From: Tom Woolner [REDACTED]
Sent: 09 October 2017 12:55
To: Paul Cann
Cc: Simon Davis; Tim Rainbird
Subject: FW: FW: BE/71/17/PL - Wickes, Bognor Drainage Scheme

Our responses to Paul Cann of Arun Council are as follows:

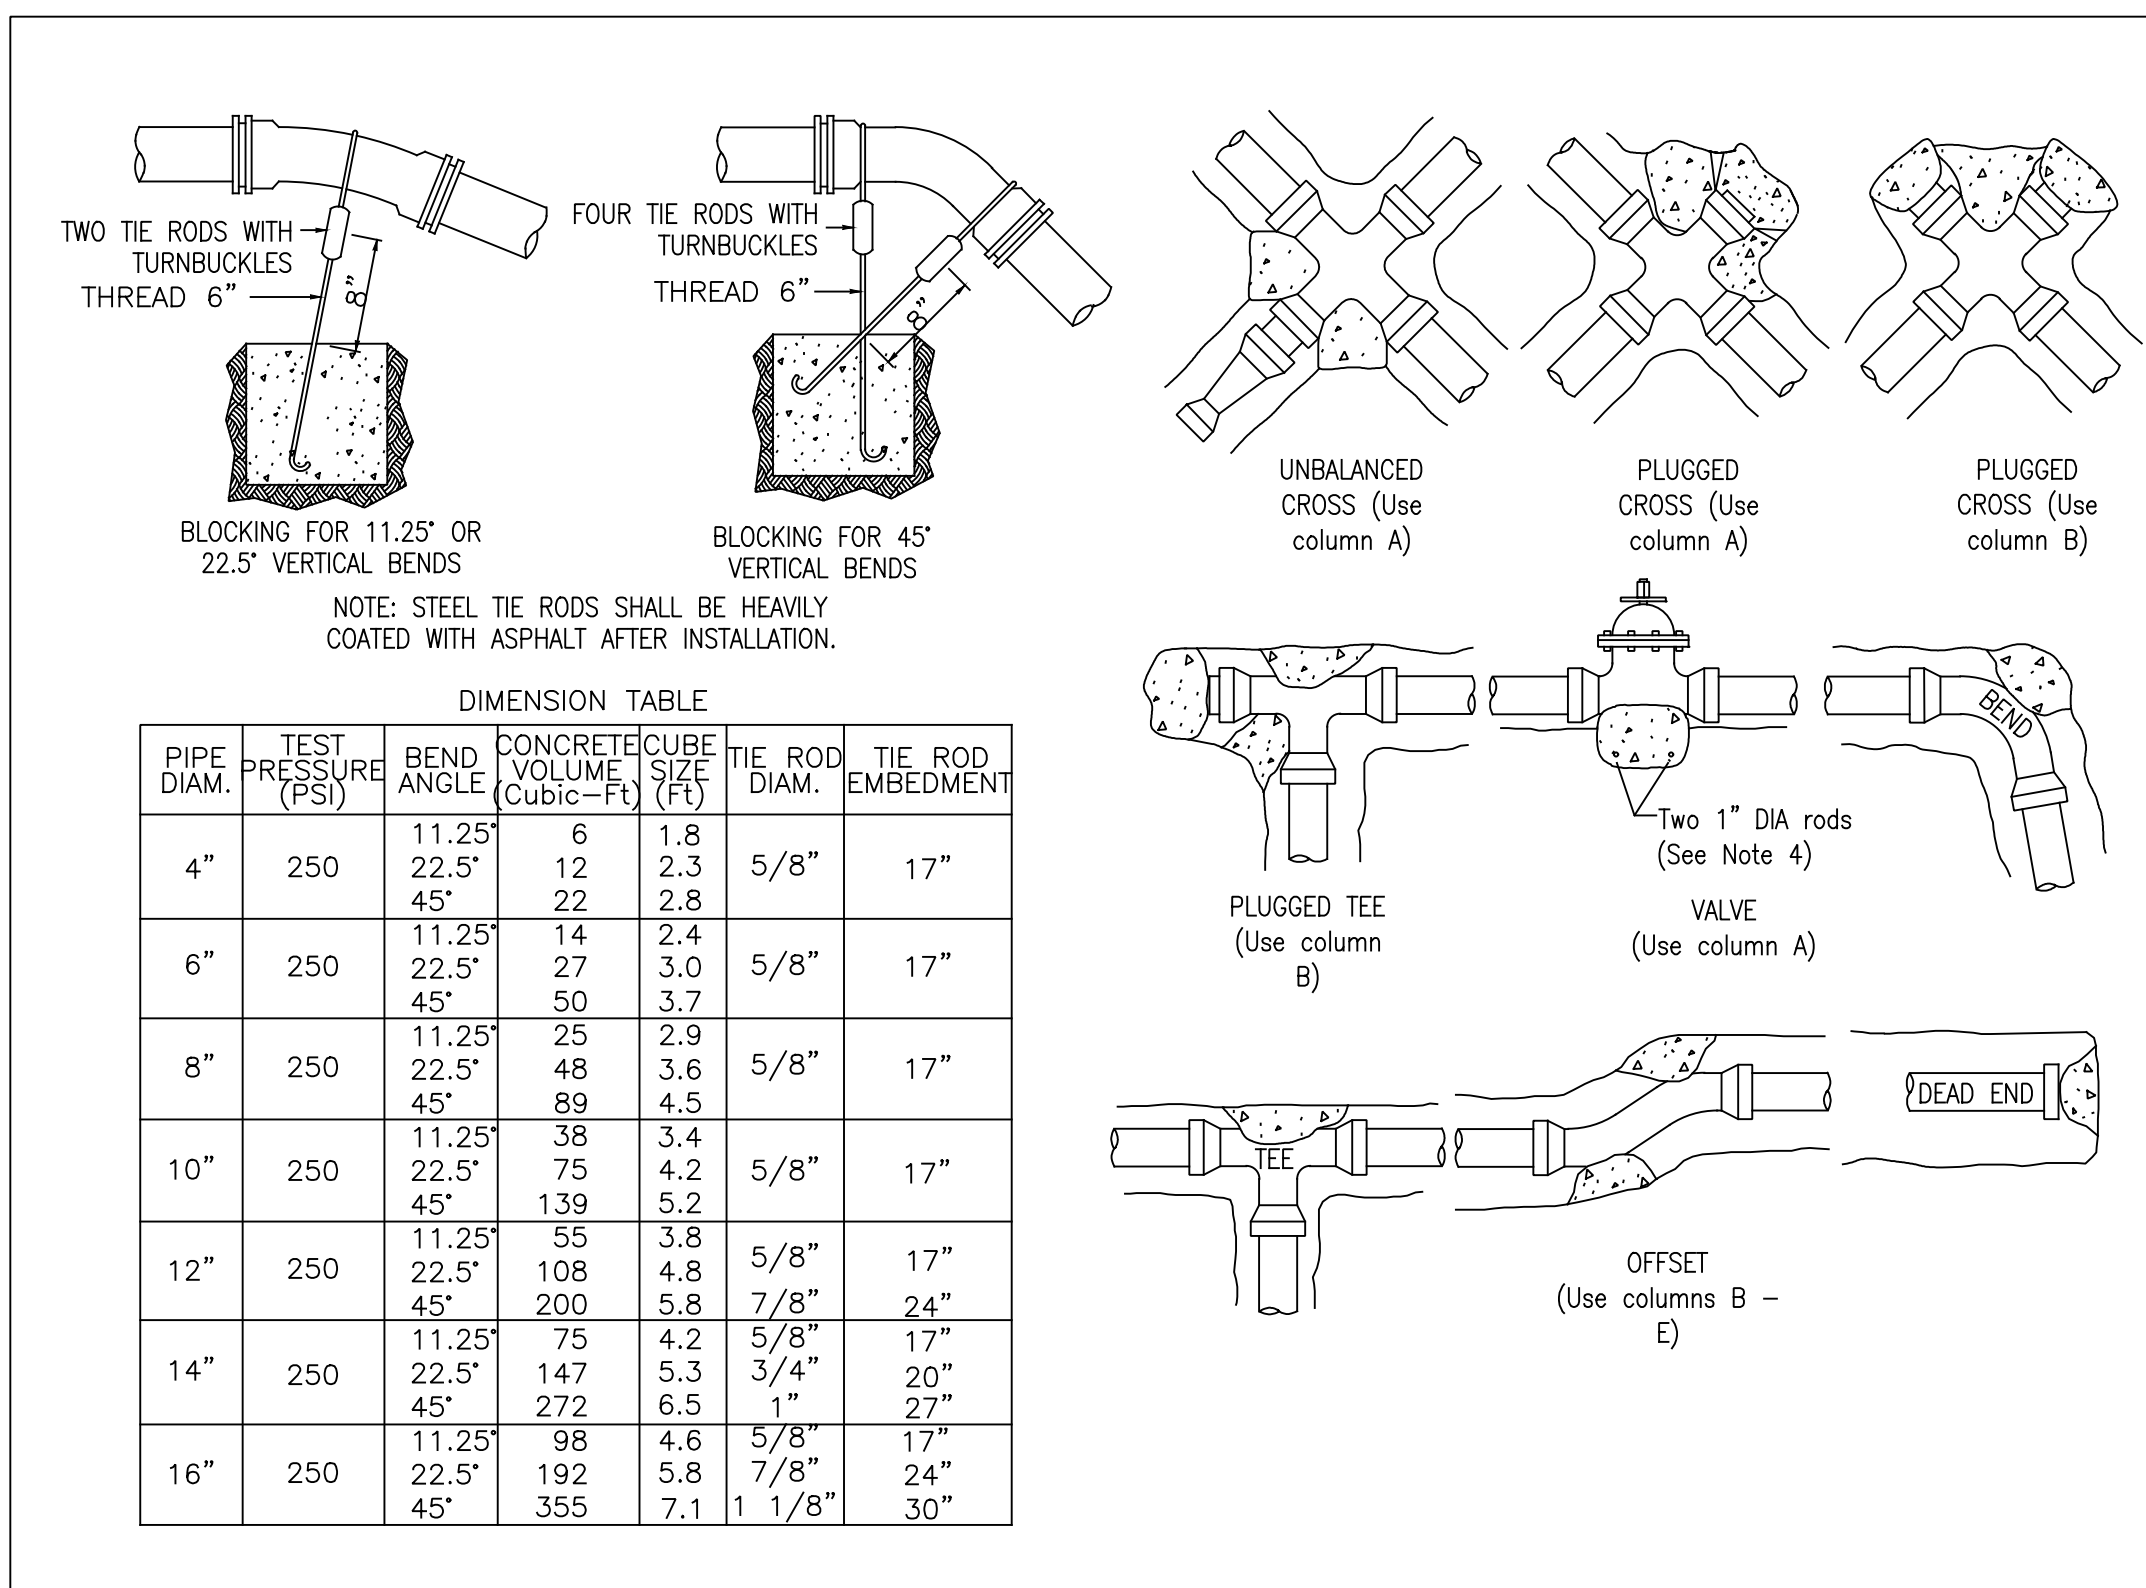
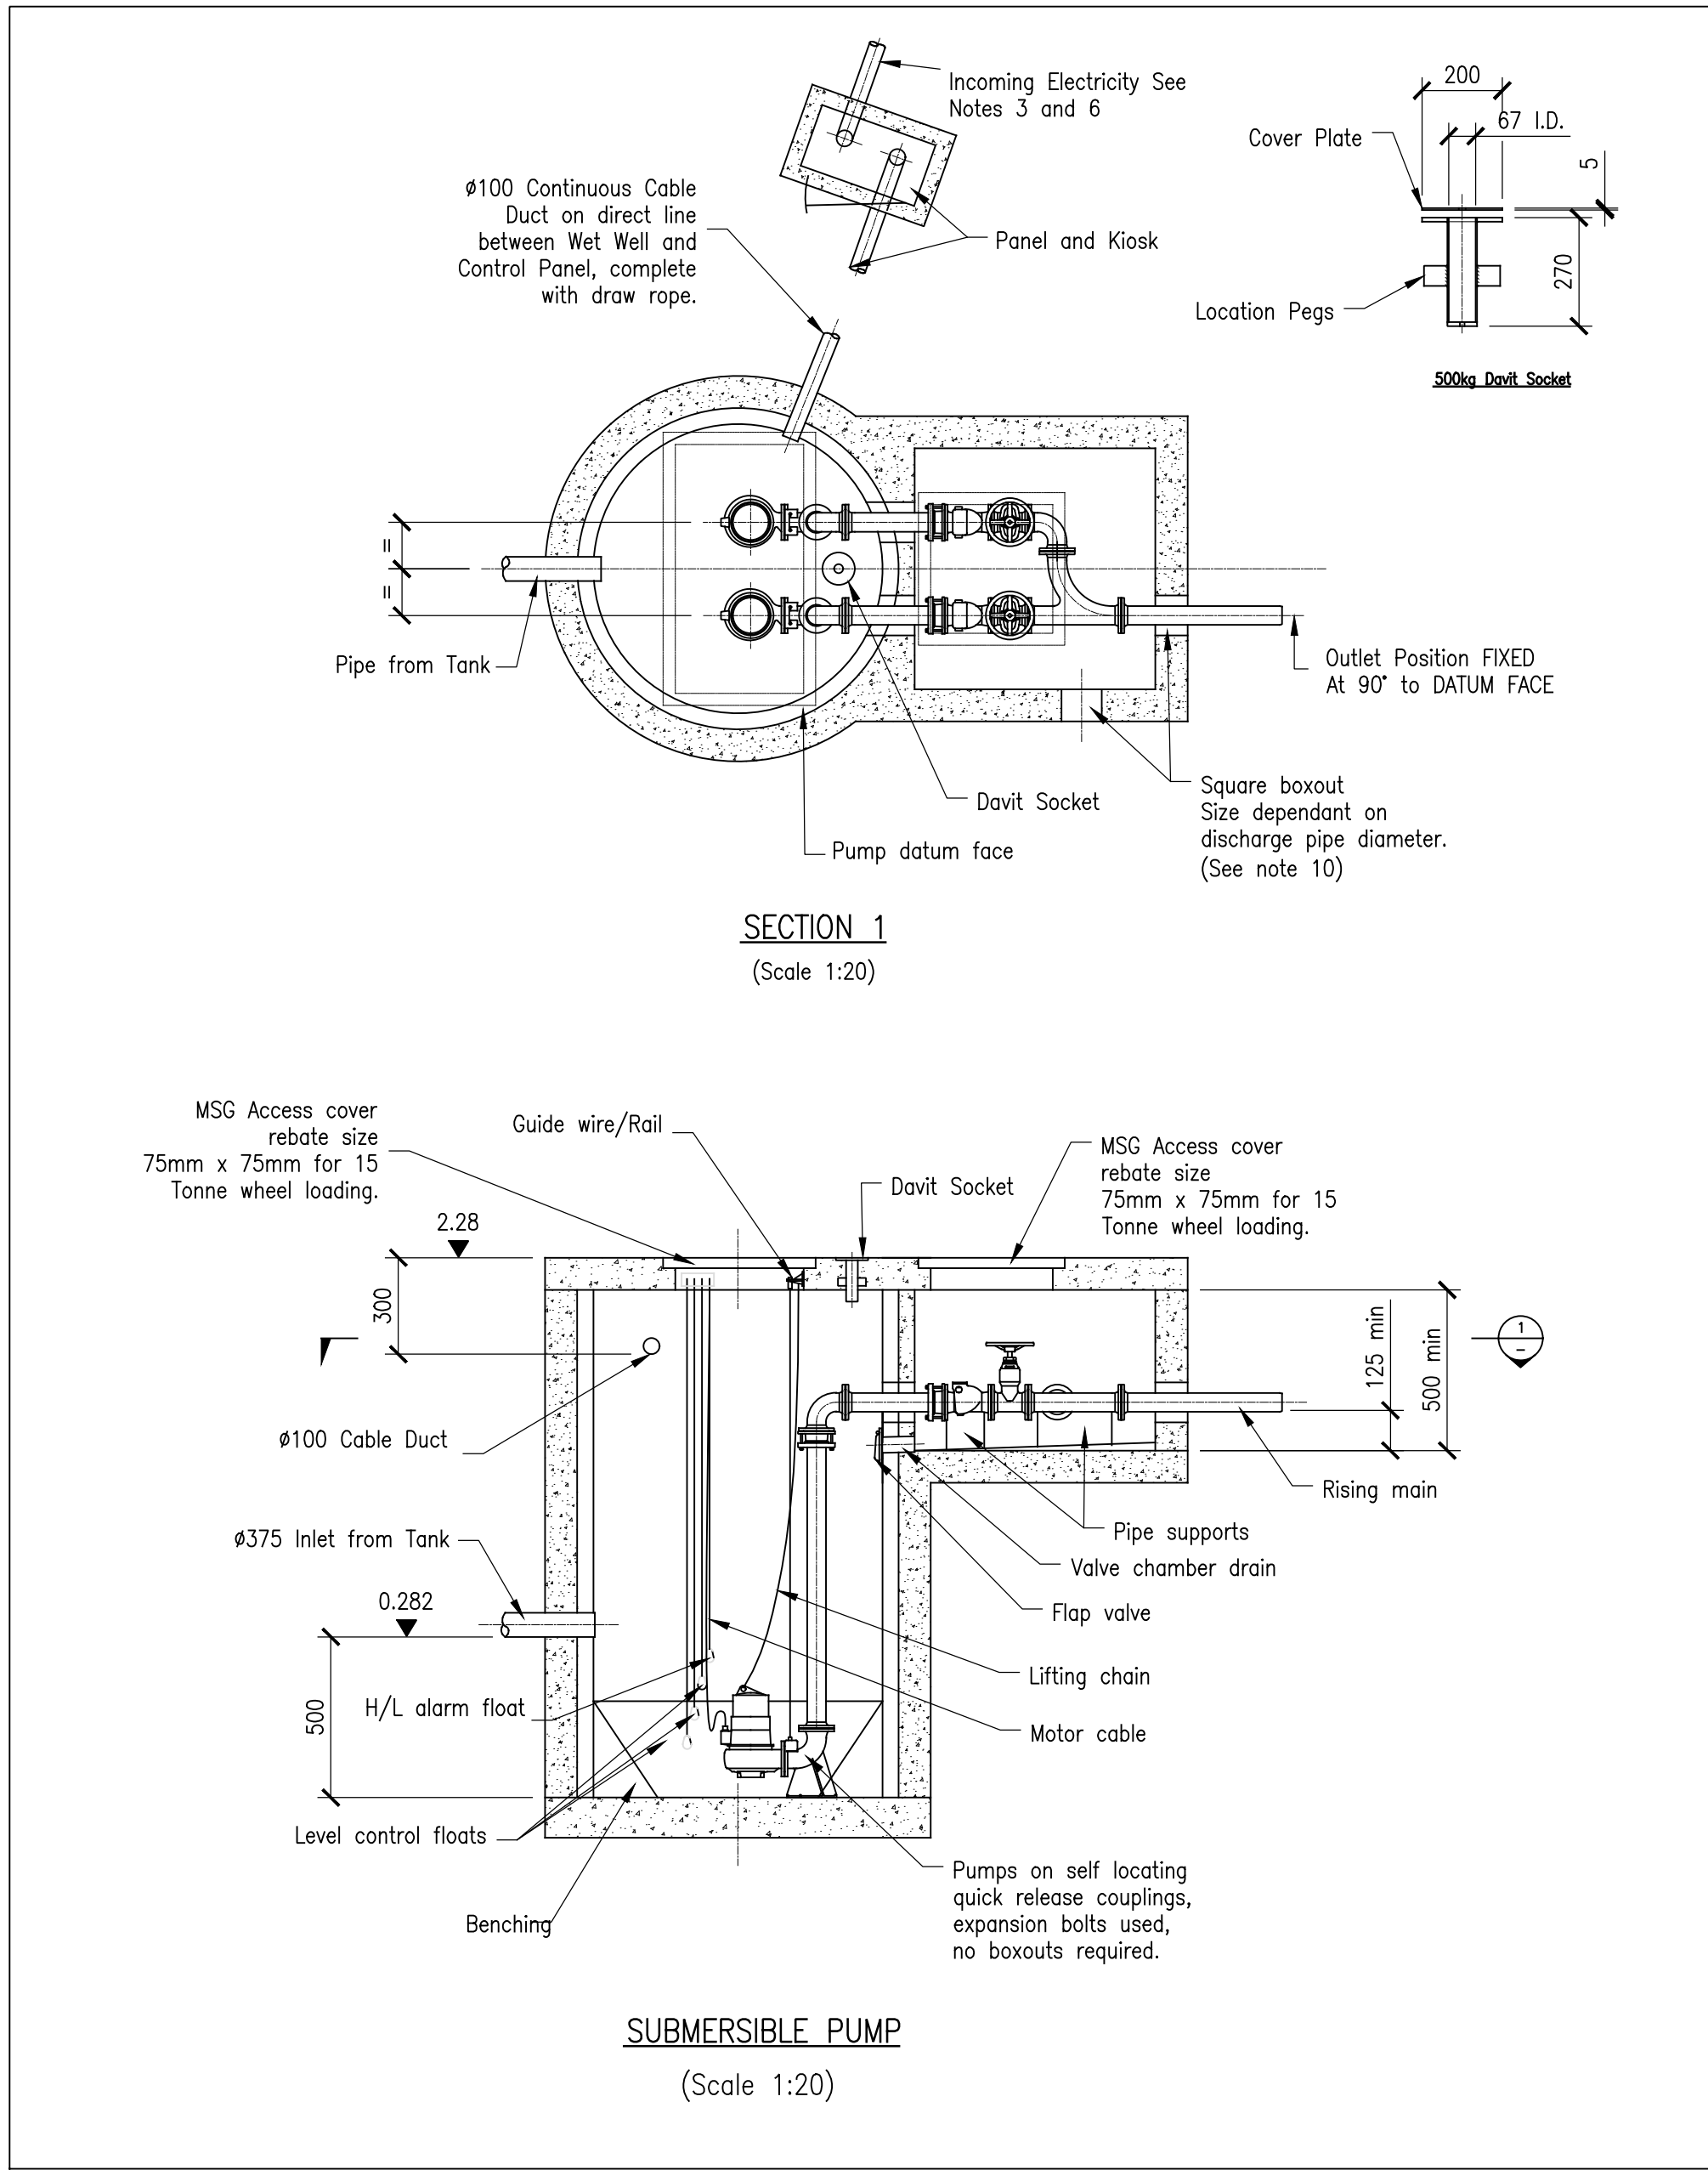
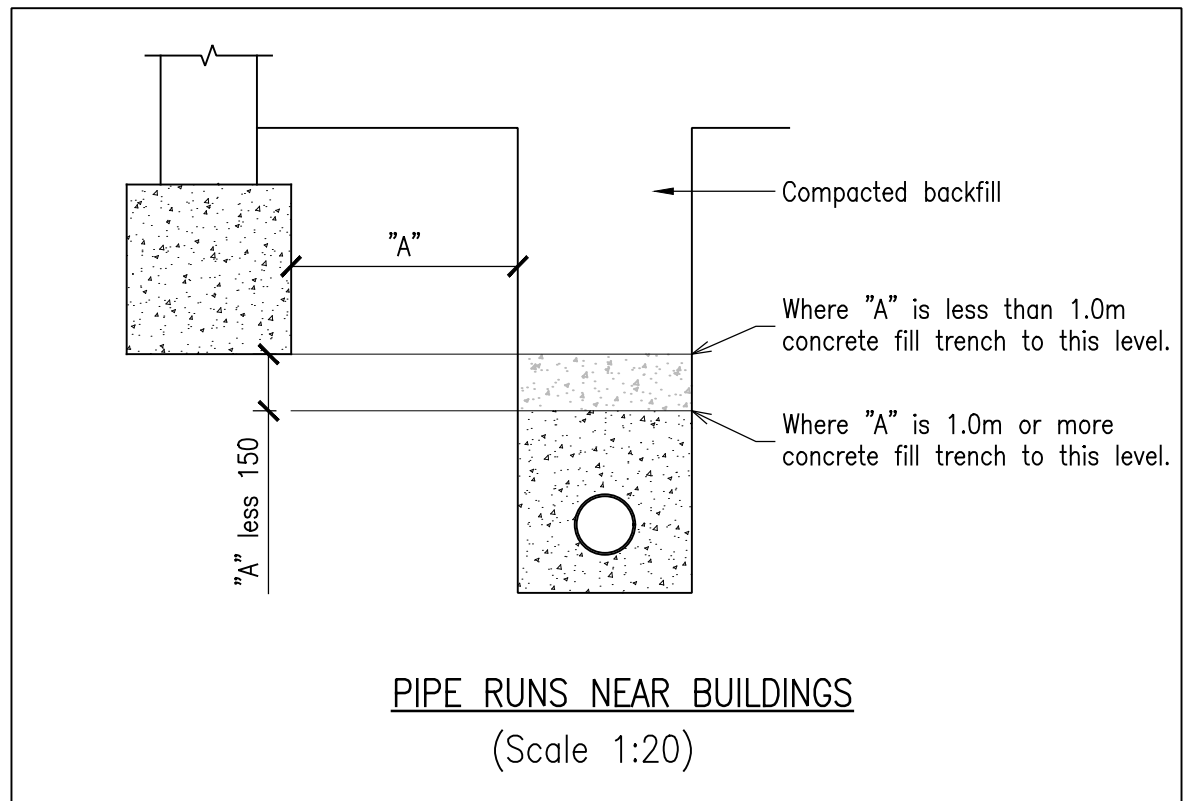
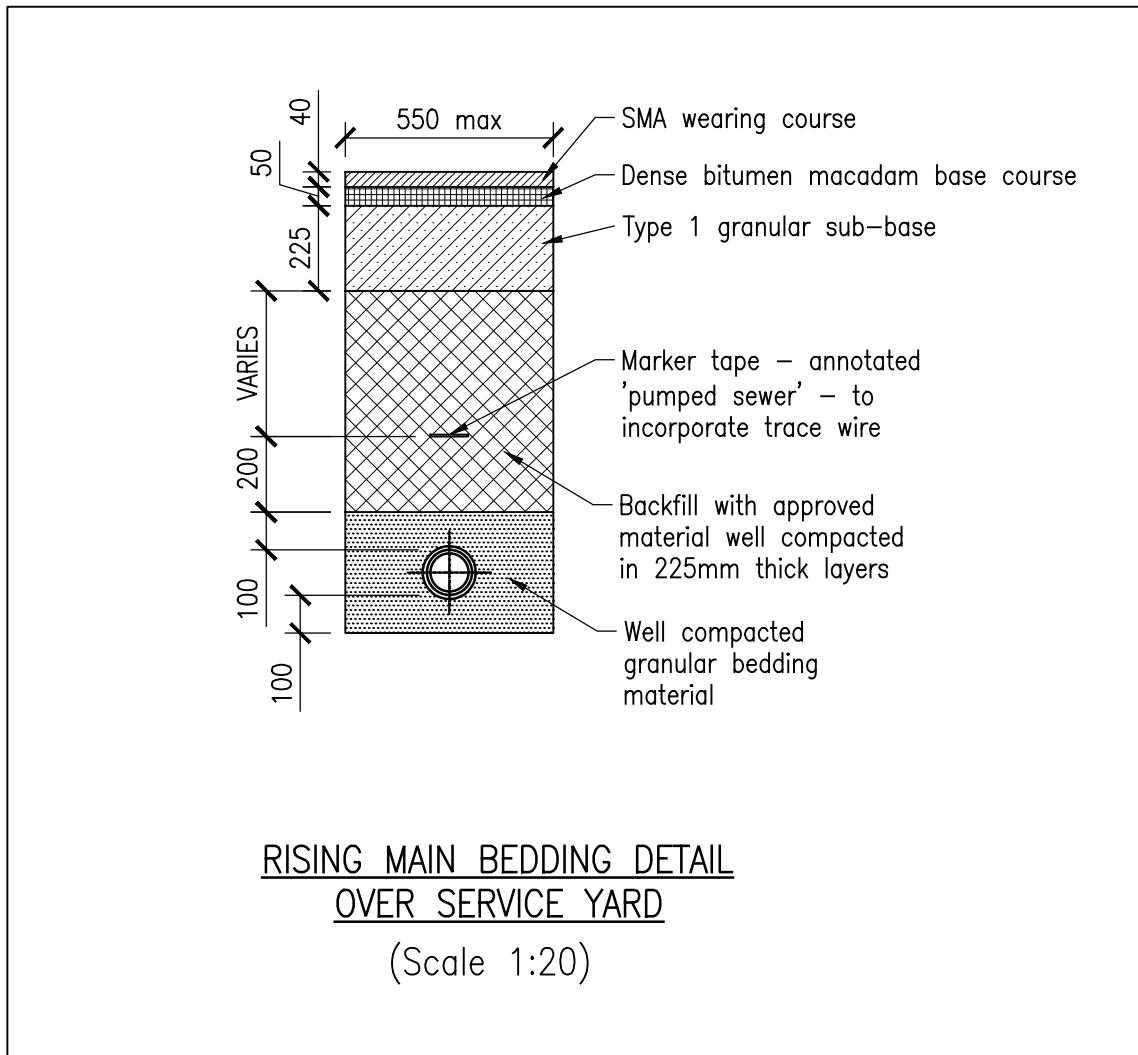
3. The construction detail for the discharge chamber refers to existing manhole S9 and a 450mm outlet pipe. This is not the case. It should show a 250mm diameter rising main with a 375mm diameter outlet. There are some spelling errors too.
